From: planning
Subject: FW: app3/2016/0178 St Peters Clos

From: Bloomer, David [<mailto:David.Bloomer@lancashire.gov.uk>]
Sent: 07 March 2016 14:46
To: Adam Birkett
Cc: LHS Customer Service; planning
Subject: app3/2016/0178 St Peters Clos

SITE PLAN

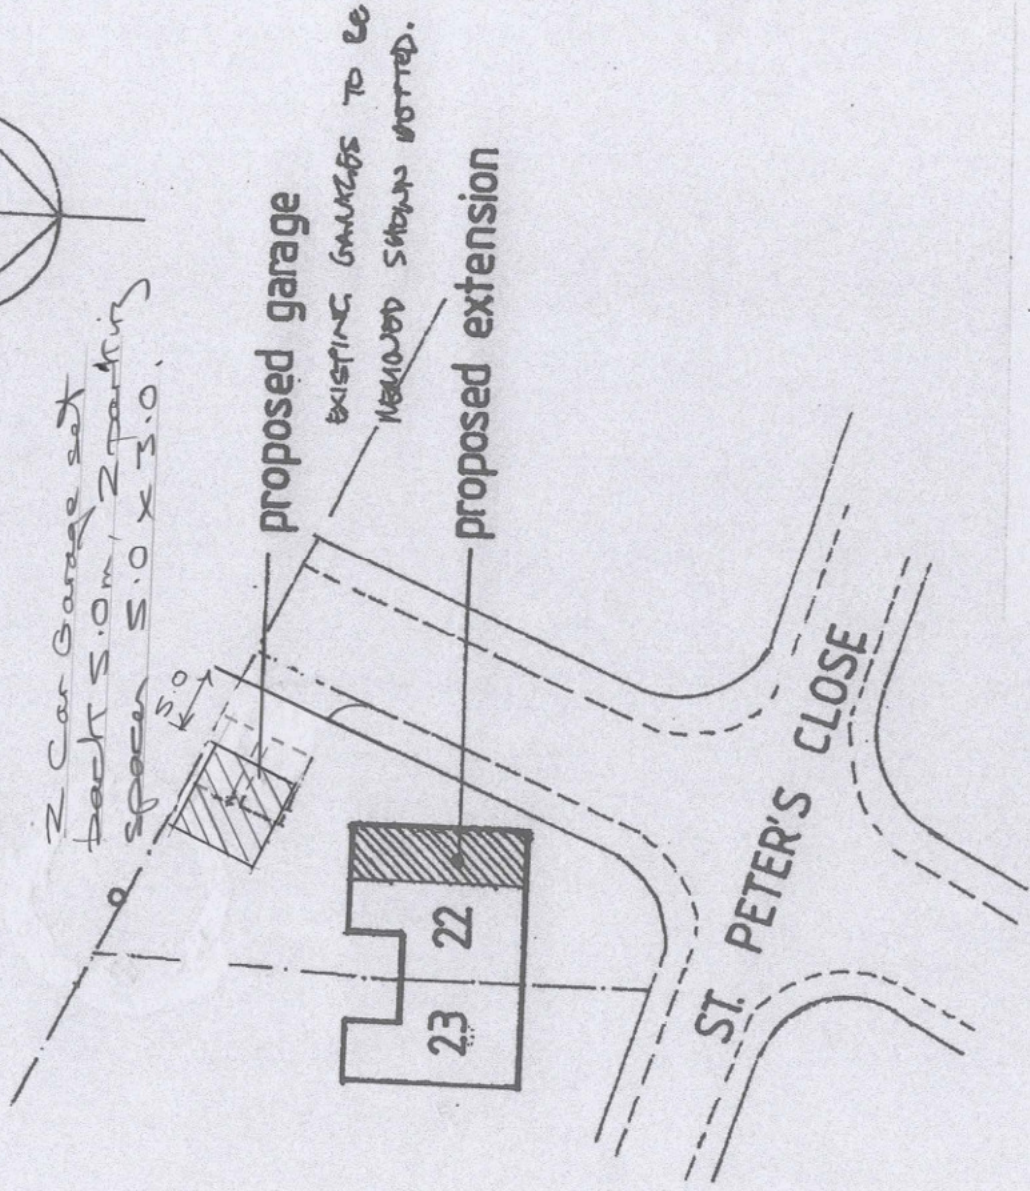
The proposal increases the number of beds at the property from the previously approved scheme of 3 beds to 4 beds without any increase in the parking provision. A 4 bed dwelling would require 3 parking spaces. Also there are no details of the garage provided with this application.

Subject to details of the garage and provision for 3 parkings spaces being provided and assuming they are acceptable I would be minded to raise no objection to the proposal on highway grounds.
